From:
Sent: 14 December 2023 13:47
To: DCAdmin
Subject: Subject: 2023/93224 – Objection to Planning Application for Rear Sunroom Extension

I hope this email finds you well. I am writing to express our objection to the planning application submitted by [redacted] at 15 Mountjoy Road, Huddersfield, HD1 5QB, for the construction of a rear sunroom extension. While understanding and respecting their desire to enhance their property, I wish to bring forth several concerns that I believe warrant careful consideration, as it would be [redacted] if we do not put this forth.

Proposed North West Elevation
15 Mountjoy Road

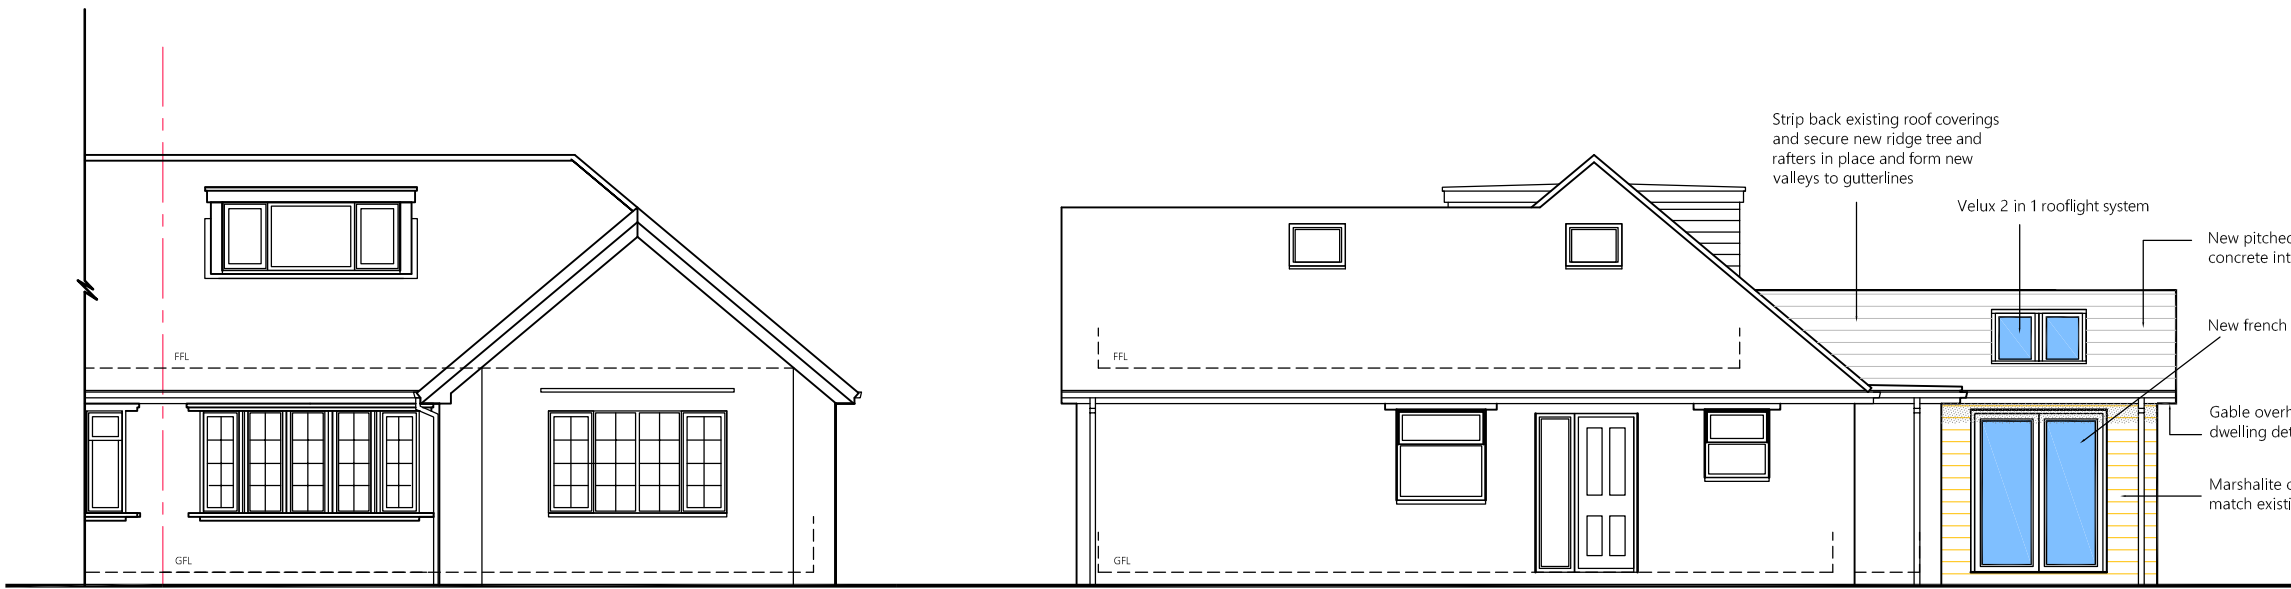
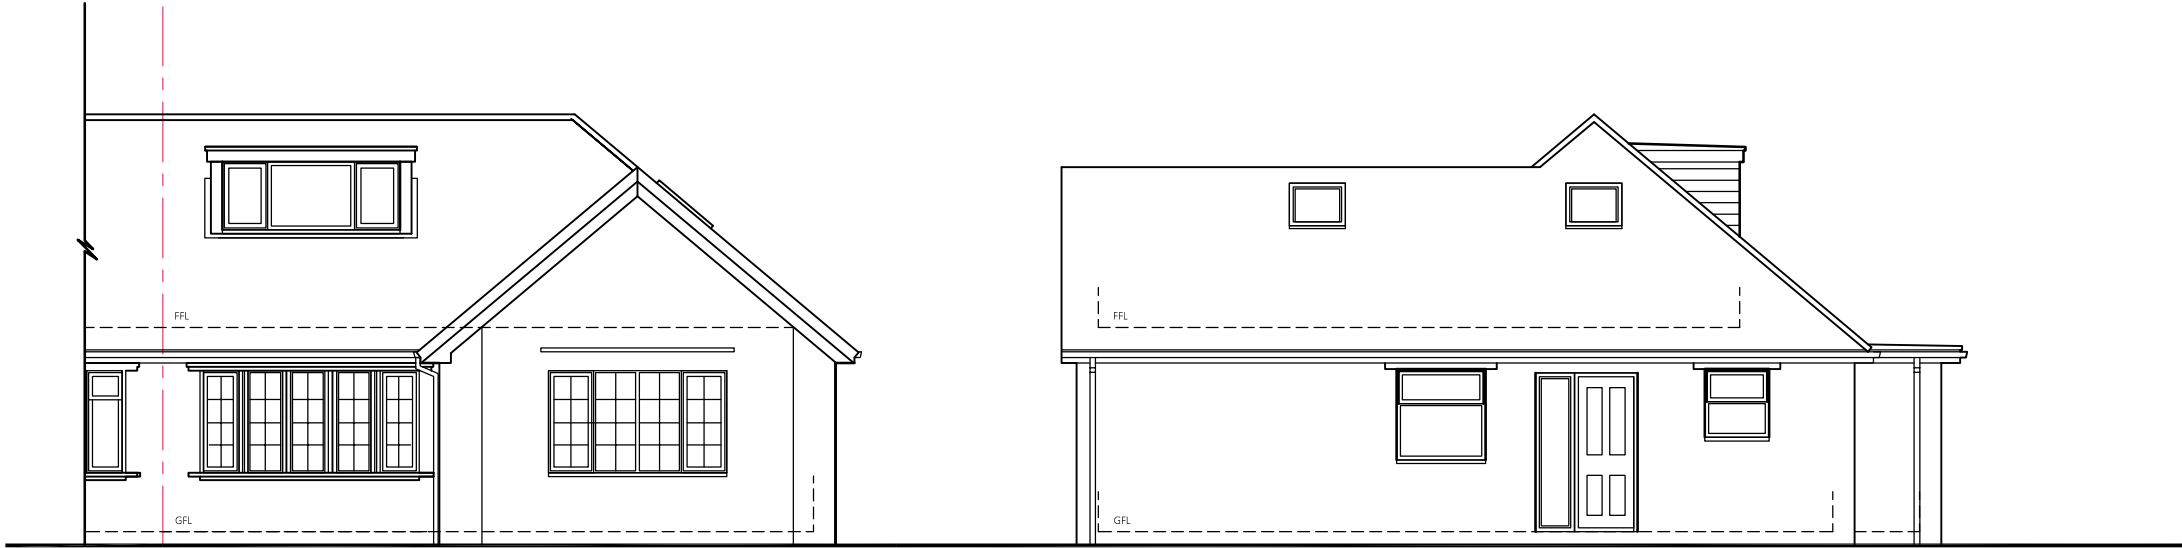
Our primary concern is the potential loss of light and overshadowing that this extension may cause. Given the orientation of [redacted], sunlight is crucial for [redacted] enjoyment and natural light into [redacted], which is currently limited due to the proximity of [redacted]. The proposed gable roof raises concerns about blocking sunlight to [redacted], further restricting [redacted] access to natural light.

Moreover, we suspect that the 4-meter extension will breach the 45-degree angle rule in the UK. This rule is in place to maintain a reasonable angle between neighbouring properties, preventing undue impact on the living conditions and aesthetics of surrounding homes. We urge an examination of the proposed extension's compliance with this rule, as any deviation could negatively affect the overall harmony of our properties.

The immediate proximity of the extension to [redacted] compounds our concerns, as well, leaving [redacted] with only [redacted] and exacerbating the sense of confinement [redacted]. Unlike other bungalows on our road with conservatory-style extensions, the proposed use of similar building materials, combined with the gable roof, raises aesthetics concerns that should be taken into account during the evaluation process. In addition, while conservatory-style roofs, and their materials, could allow natural light to pass through [redacted], again it seems that the gable roof (and its height) [redacted] proposed is the concerning issue.

Proposed Ground Floor Plan
15 Mountjoy Road

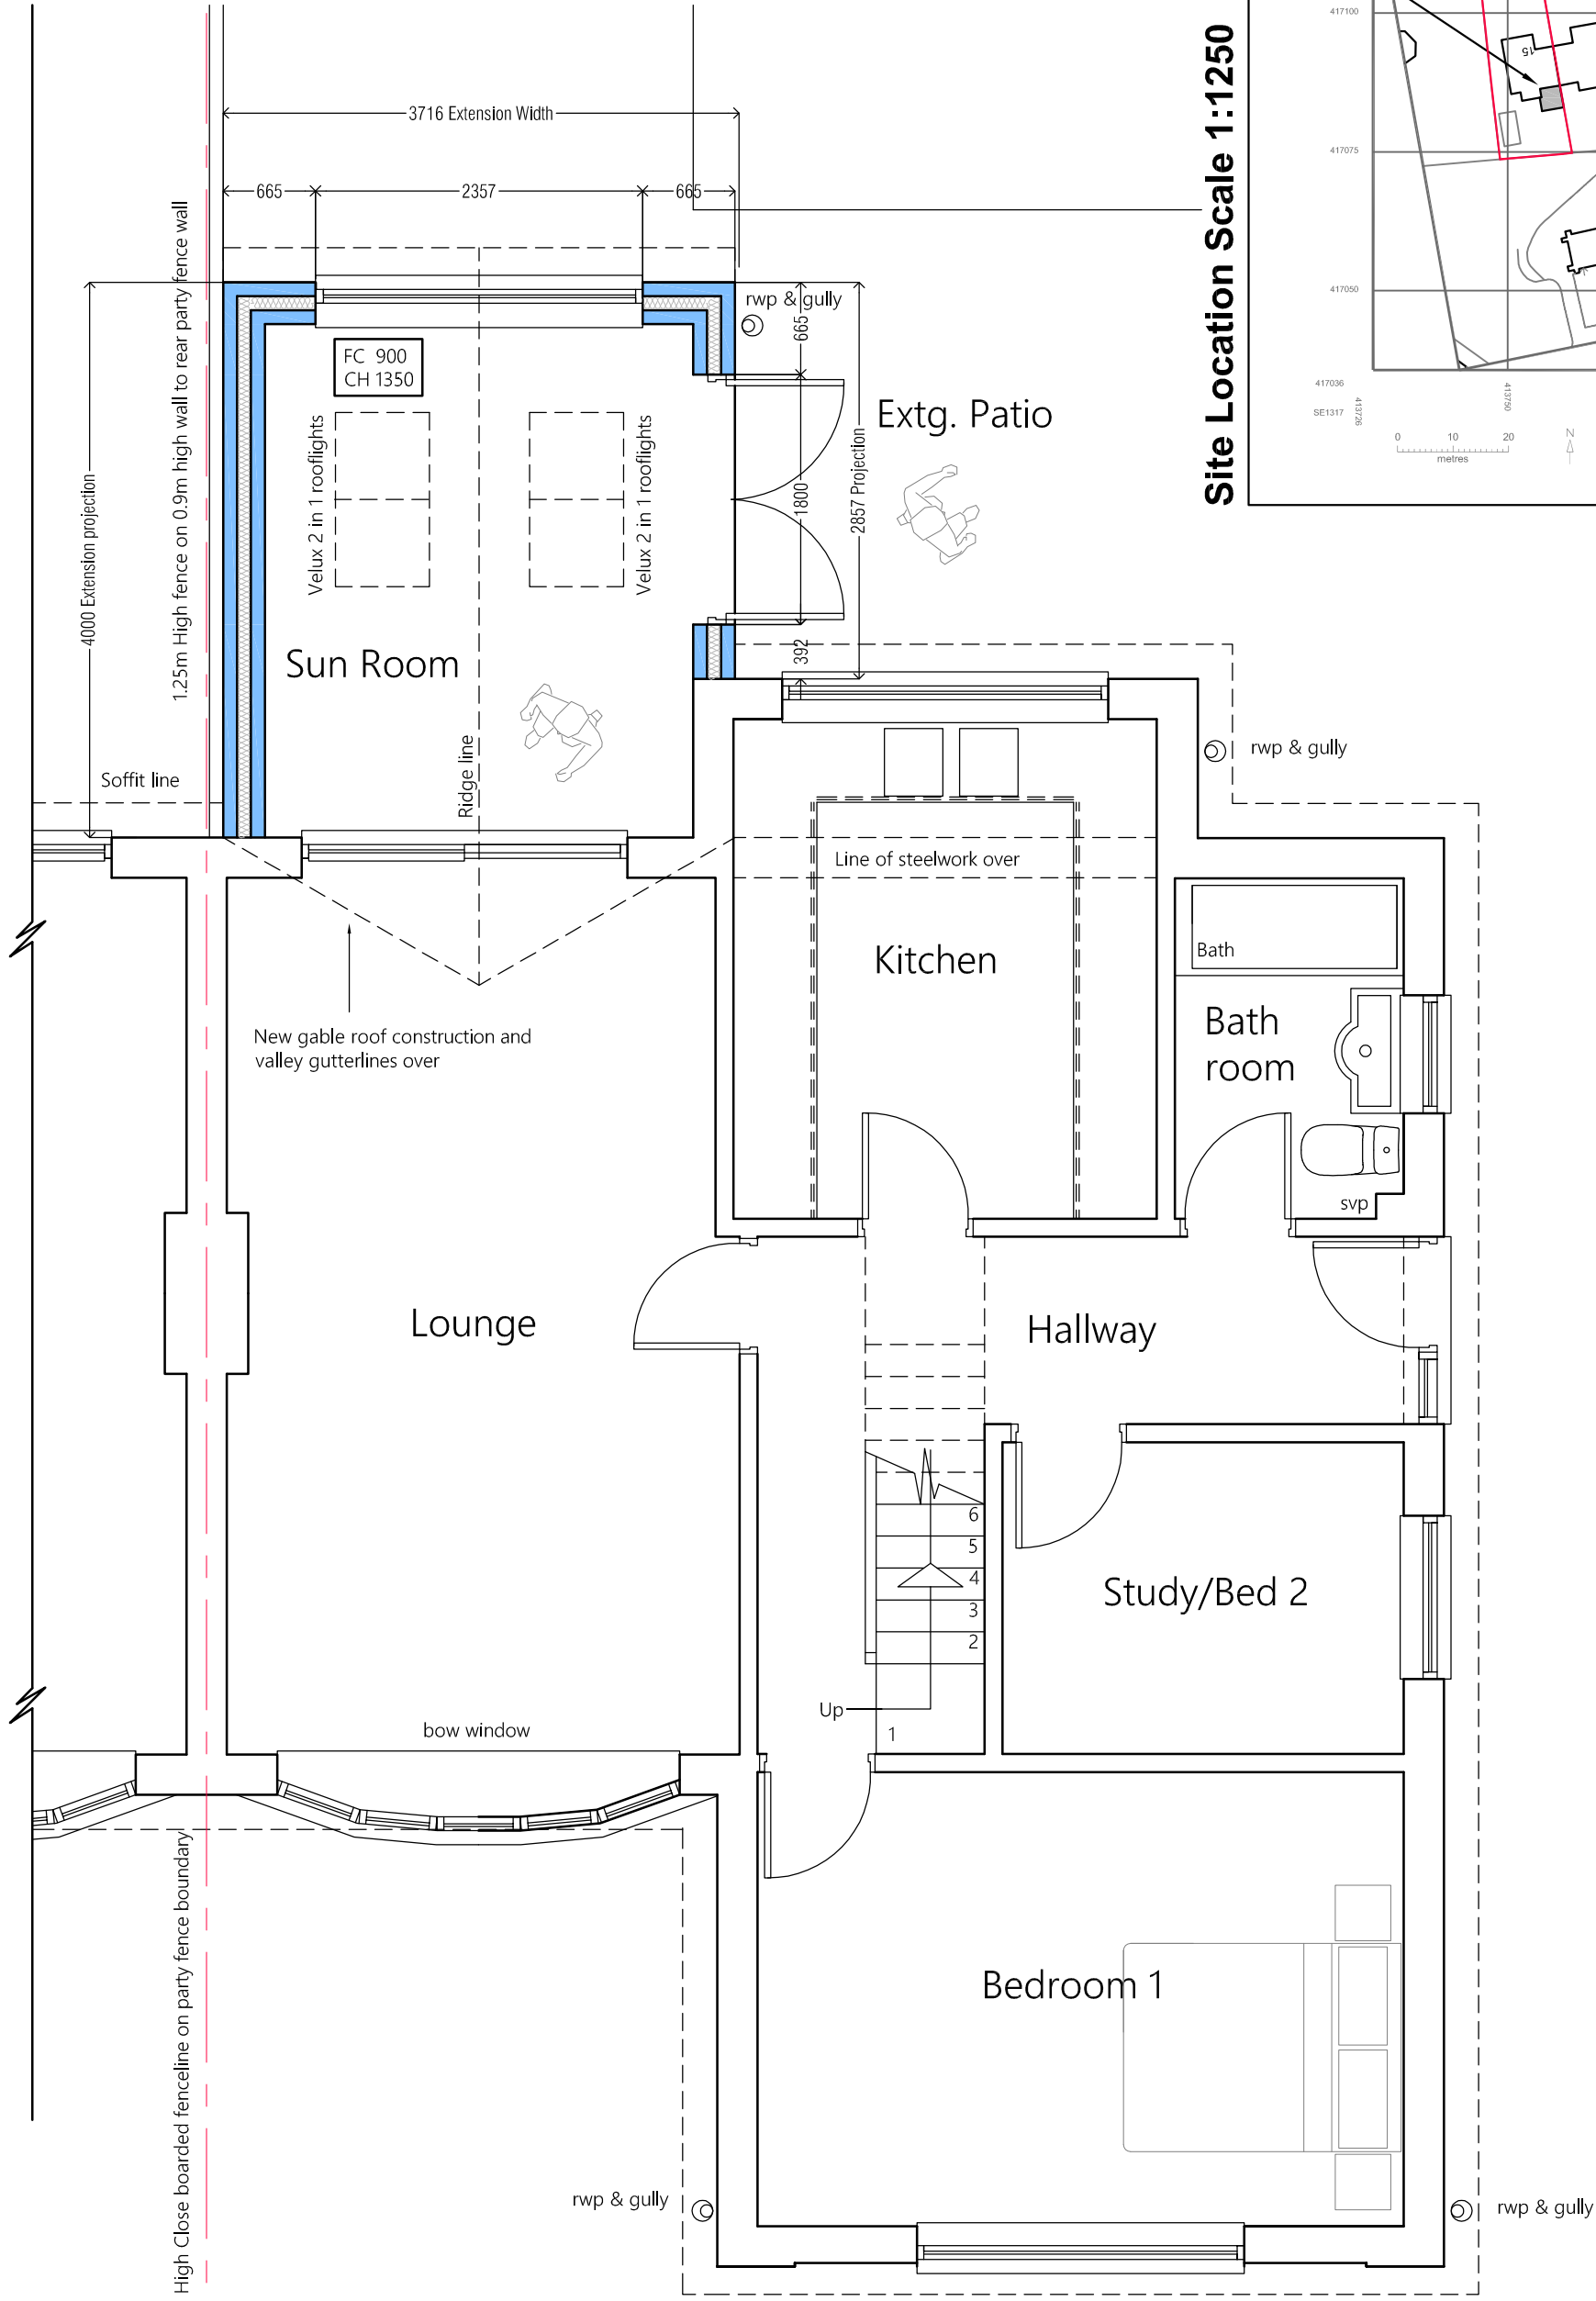
Additionally, we are troubled by the lack of detailed plans regarding the gap between the extension
. Given large trees causing leaf accumulation and stagnant
water, we are concerned about potential foul smells , as well as water and
decomposition damage It is crucial that the plans address proper
ventilation and maintenance to prevent unpleasant odours.
